WEST SUSSEX COUNTY COUNCIL CONSULTATION

TO:	Arun District Council FAO: Amber Willard
FROM:	WSCC - Highways Authority
DATE:	16 December 2020
LOCATION:	16 North End Road Arundel BN18 0DJ
SUBJECT:	Y/129/20/HH Installation of vehicular crossover. An amendment received.
DATE OF SITE VISIT:	n/a
RECOMMENDATION:	Advice
S106 CONTRIBUTION TOTAL:	n/a

GA front access

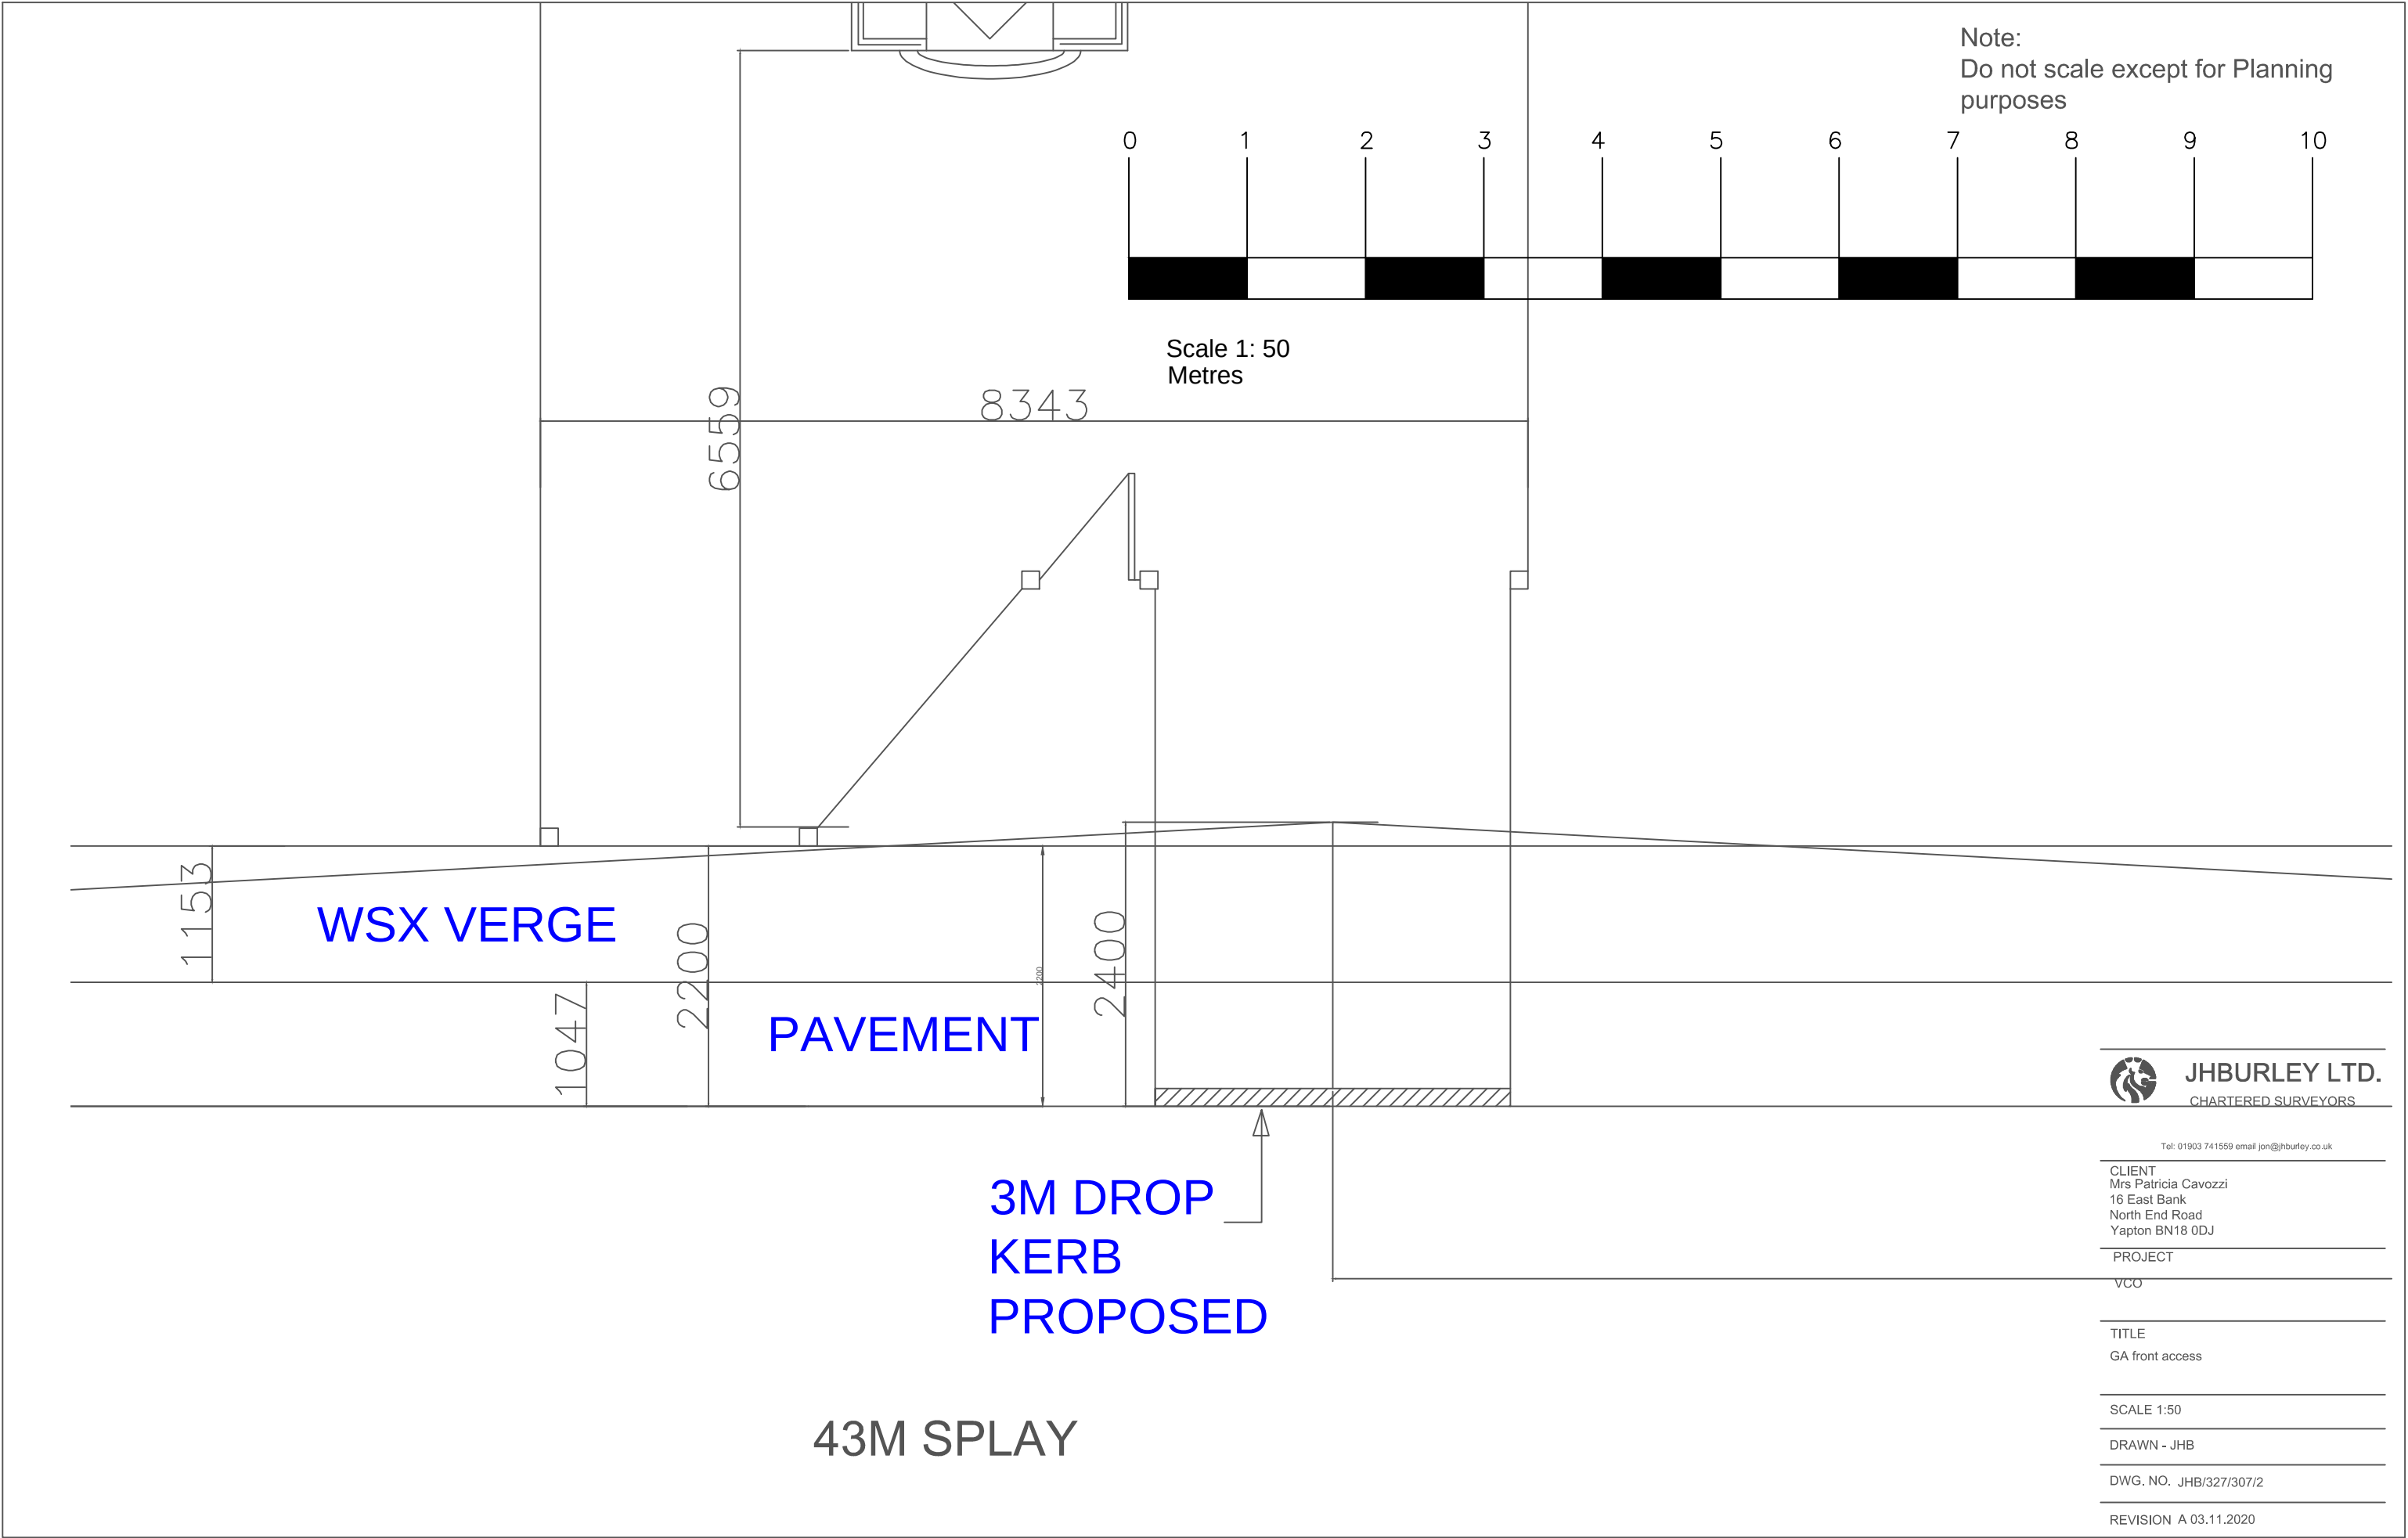
The applicant proposes a 3 metre VCO. The LHA wishes to make all parties aware that VCO's under 4.5 metres or over 6.4 metres are generally not accepted at the licensing stage. Though in this instance, such a provision is not considered a highway safety concern. The applicant should be mindful that this may result in, if successful, a planning permission that cannot be implemented. Therefore, the applicant is recommended amending the plans to show a kerbside VCO of between 4.5 – 6.4 metres. Details of which can be secured via a suitably worded condition.

The use of the car parking space(s) shall not commence until the vehicular access has been constructed in accordance with plans and details **to be** submitted to and approved in writing by the Local Planning Authority.

TITLE
Splay

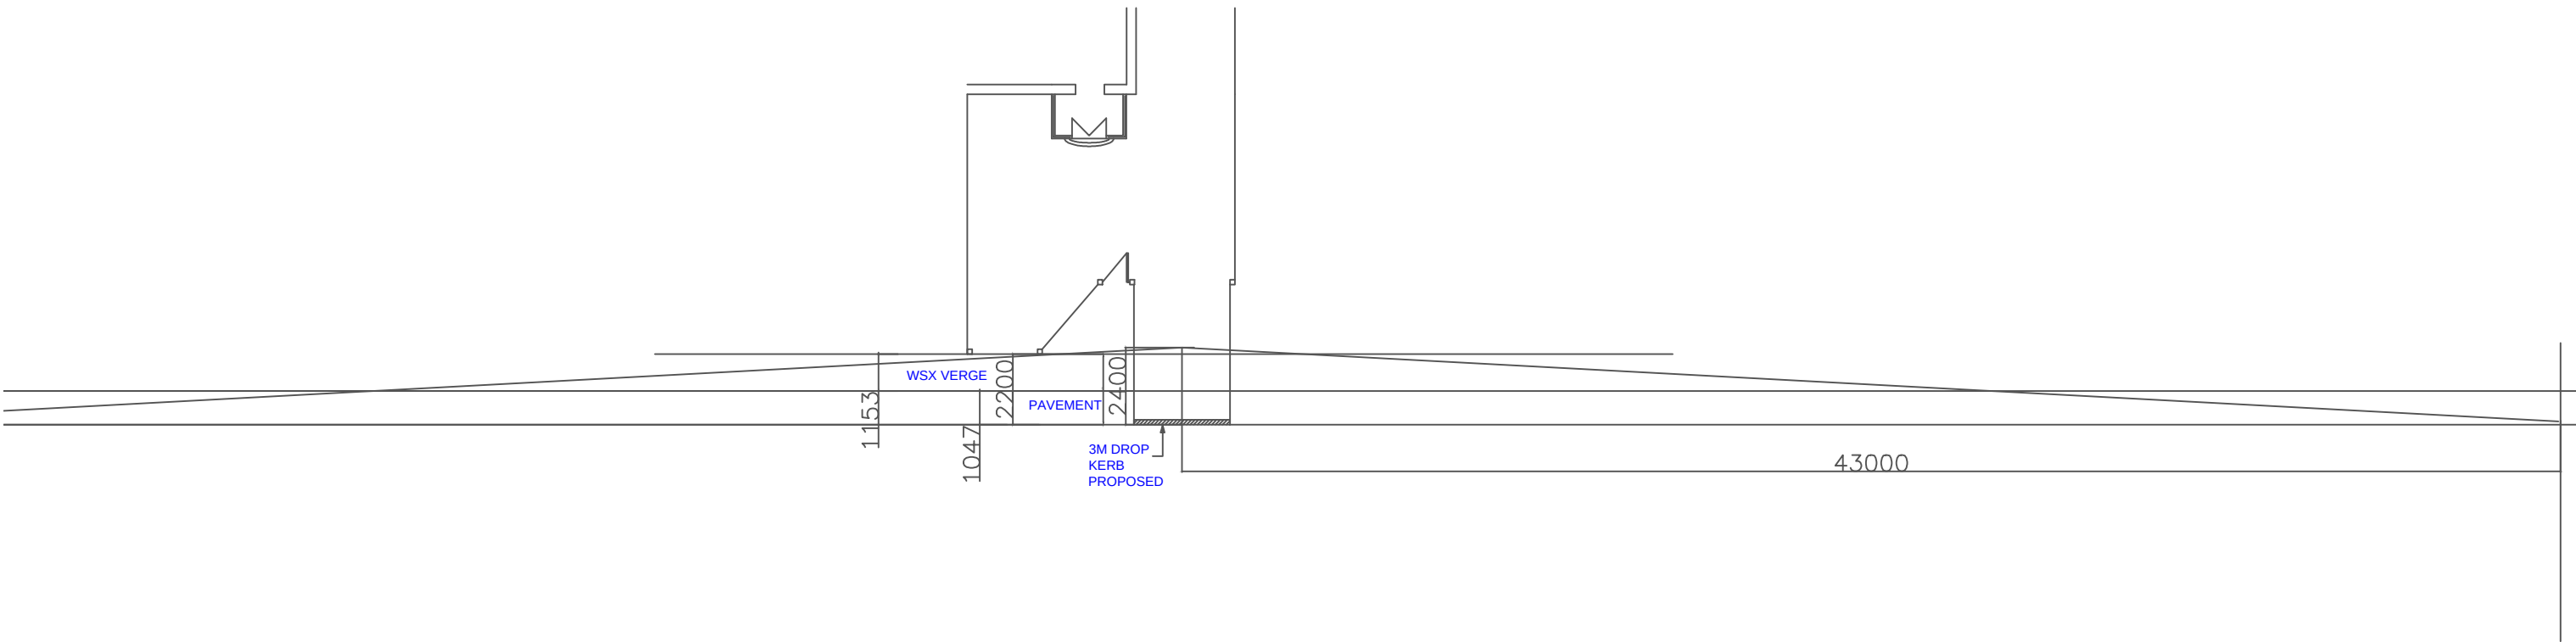
The applicant has provided the following acceptable visibility splays in conjunction with MfS guidance.

Southbound – 2.4 x 75 metres.
Northbound – 2.4 x 55 metres.

The use of the access shall not commence until visibility splays of,

Southbound – 2.4 x 75 metres,
Northbound – 2.4 x 55 metres,

have been provided at the proposed site vehicular access onto North End Road in accordance with plans and details submitted to the Local Planning Authority. The splays shall be maintained and kept free of all obstructions over a height of 0.6 metre above adjoining carriageway level or as otherwise agreed.
